MEMORANDUM

DATE: May 6, 2024

SUBJECT: Esteban Rodriguez Subdivision Sketch Plan – SKP237
RE: Traffic Impact Study
Response to CDOT Comments
LSC #S224630

Following are the LSC Transportation Consultants, Inc. responses to the January 2, 2024 Comment Letter prepared by CDOT – Region 2 – Traffic & Safety – Permits regarding SKP237.

Directional Distribution

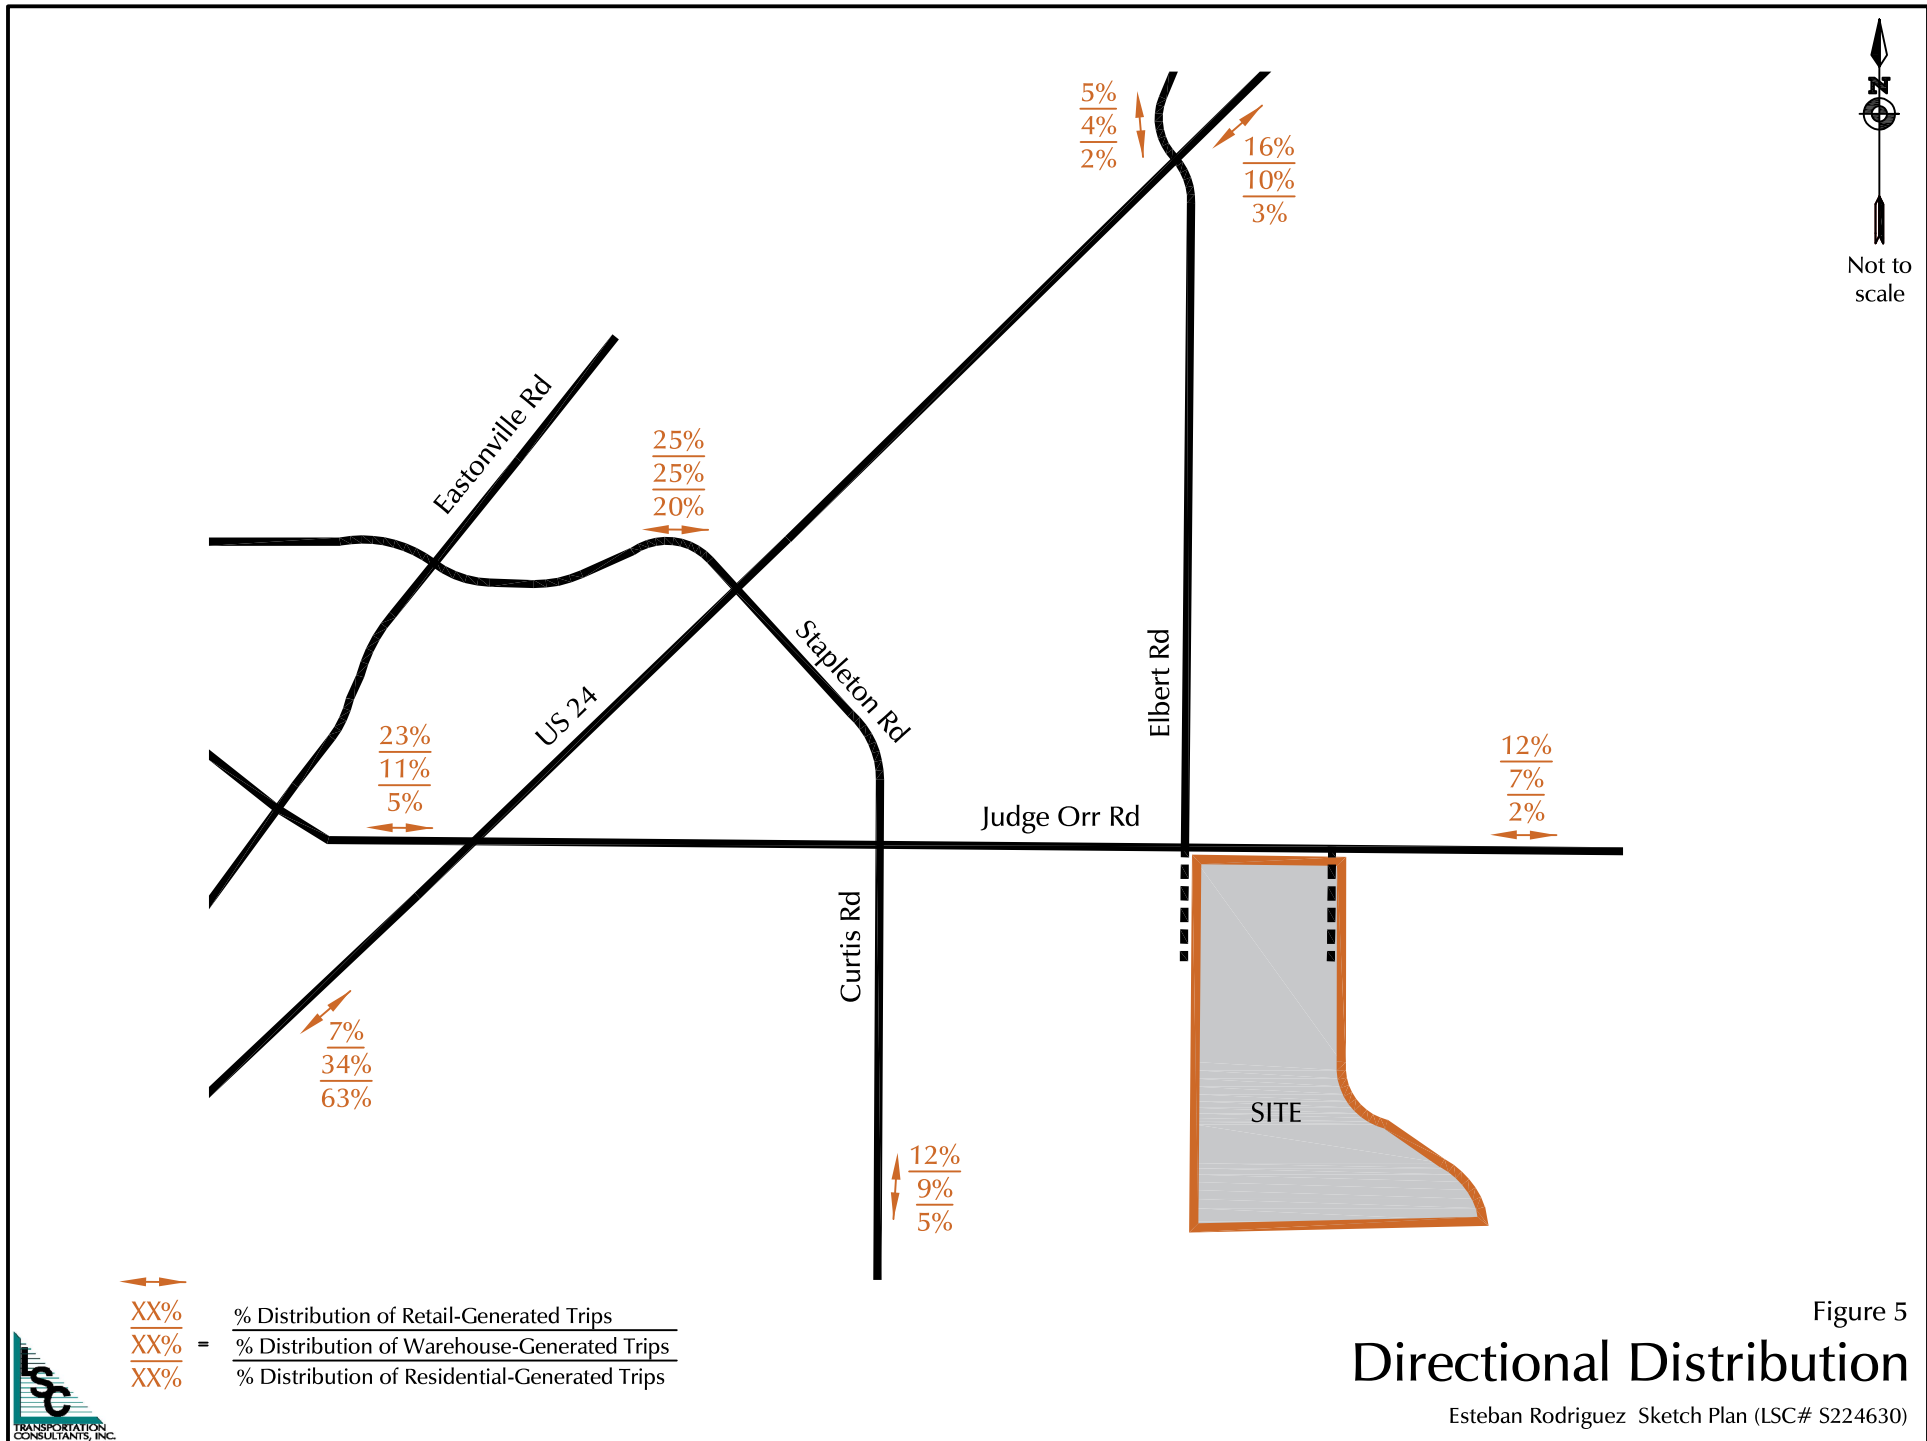
- e. *Graphically show traffic distribution.*

LSC Response: An estimated directional-distribution figure is now included in the set of figures.
